Our ref: STH06/01275/02
Contact: Andrew Lissenden 4221 2769
Your ref: PA06_0074 MOD 5

PEPPERTREE QUARRY – MODIFICATION 5 (PA 06_0074 MOD 5)

Roads and Maritime Services (RMS) refers to your email dated 1 November 2018 regarding the above application to modify the project approval for the Peppertree Quarry.

Figure 6 | Proposed haulage scenarios

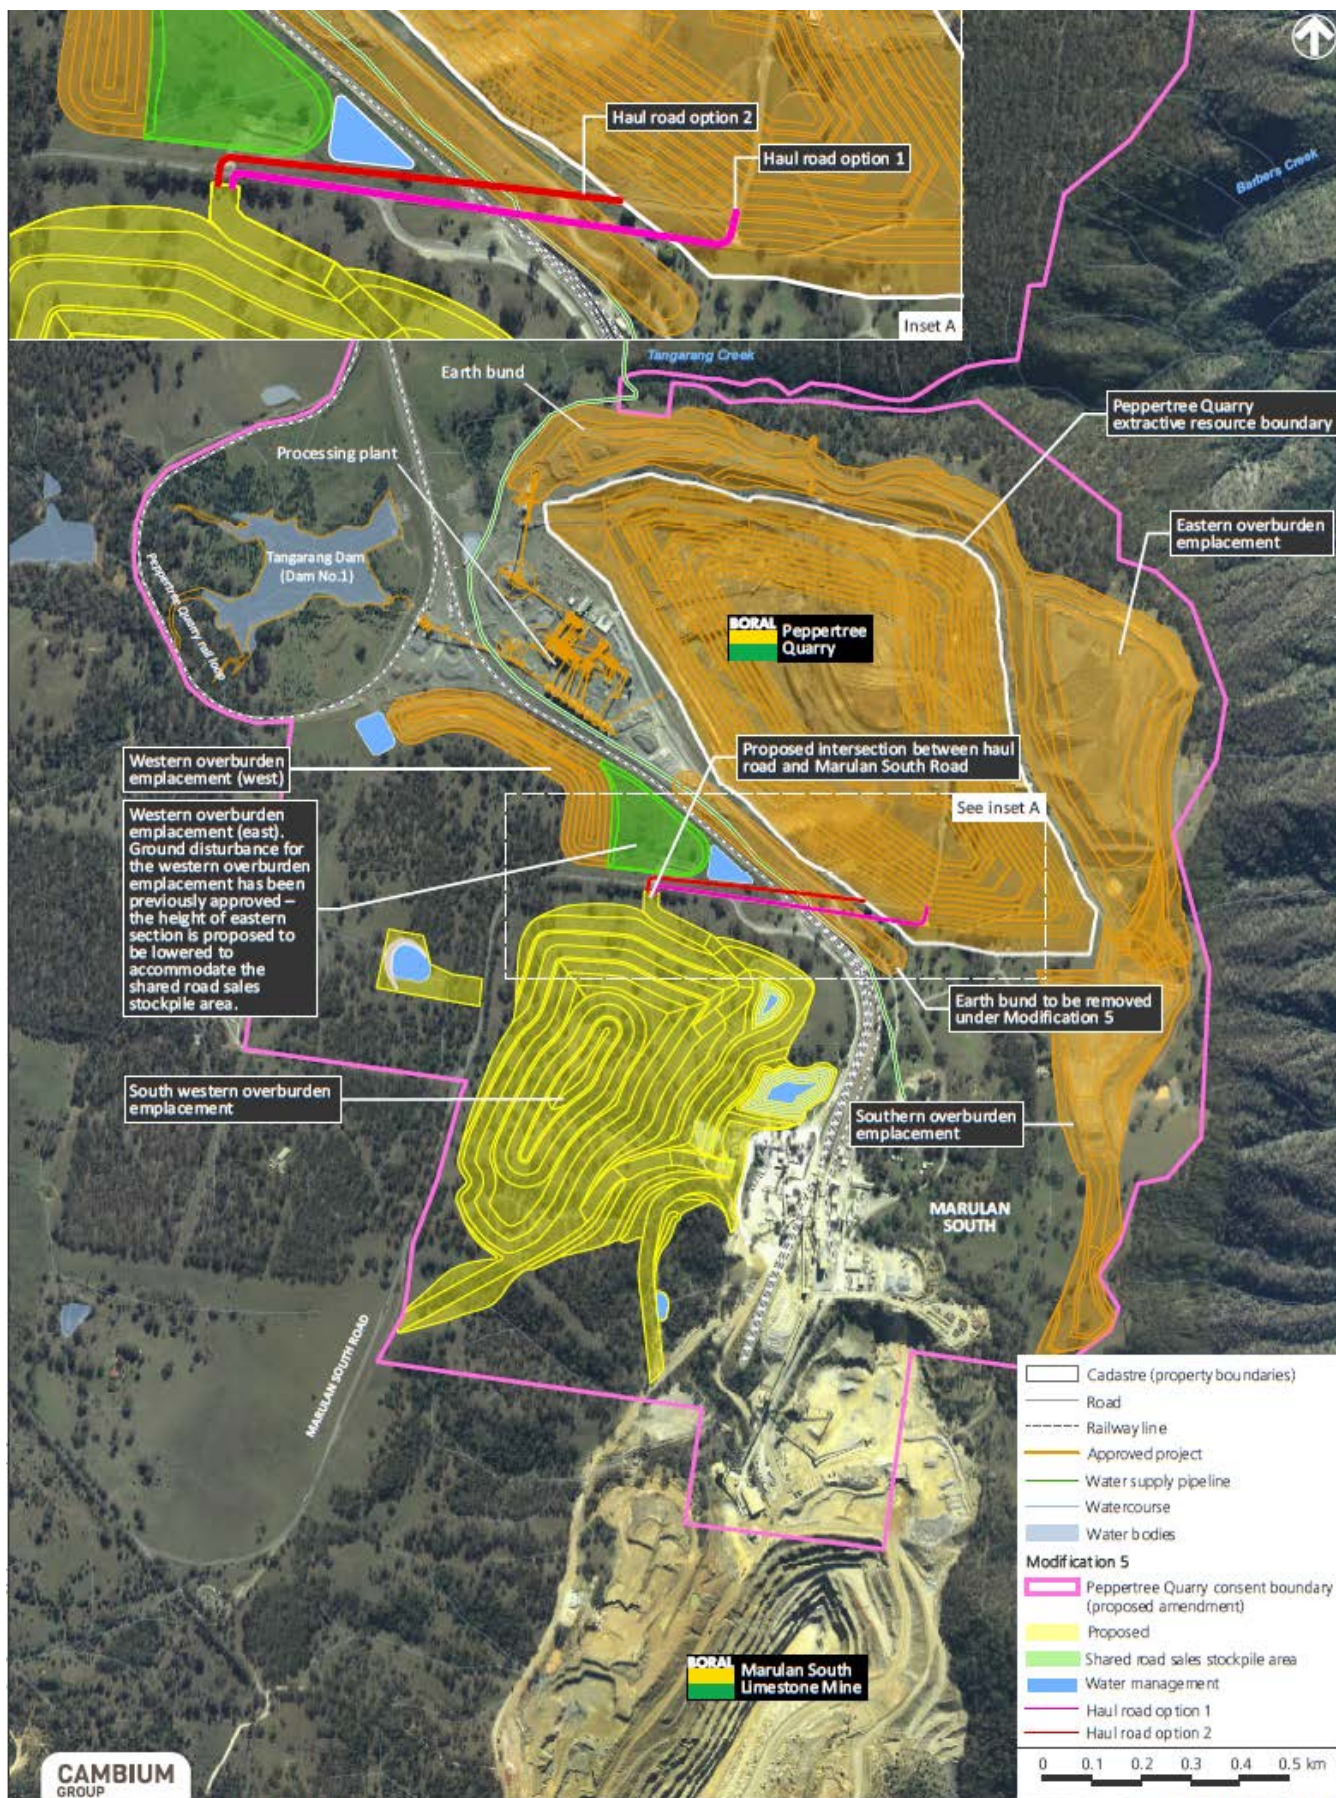
RMS does however note that the proposal is seeking to construct a new intersection on Marulan South Road to allow trucks hauling overburden material from the quarry to cross Marulan South Road and access a new overburden area (South-west Overburden Emplacement) that is proposed as part of this modification. The Environmental Assessment advising that the quarry owner is negotiating with Council to

deproclaim/deregister the affected section of Marulan South Road and if it becomes a private road then future intersection operation may be provided via traffic signal control. Noting this RMS suggests that the following requirement is included as a condition in any modified approval issued.

- If traffic signals are to be installed at the intersection of the new Haul Road and Marulan South Road (refer to *Peppertree Quarry Modification 5 Environmental Assessment* prepared by Element Environment, Revision 3, dated 31 October 2018) the following requirements should be complied with:

- If there is uncontrolled access to the site and it is open to any vehicle wishing to enter the site, then even if the road (i.e. Marulan South Road) is privately owned, it is regarded as a road related area under the *Road Transport Act 2013* and RMS must authorise any traffic signal installation. Hence the design, installation and operation must comply with RMS policy and guidelines and approval must be gained from RMS prior to their installation; or

- If there is a controlled access to the site via a barrier, gate, security checkpoint or any other means, then the road (i.e. Marulan South Road) within the site is deemed a private road, in which case RMS has no role in the authorisation of traffic signals and the property owner is not obliged to follow RMS policy or guidelines. In this situation the property owner carries all the risk and RMS staff will not audit or comment on the design, installation or operation of the traffic signals. Noting that RMS policy and guidelines in regard to the design, installation and operation of traffic signals do exist it would be good practice in this scenario to use these documents for guidance.
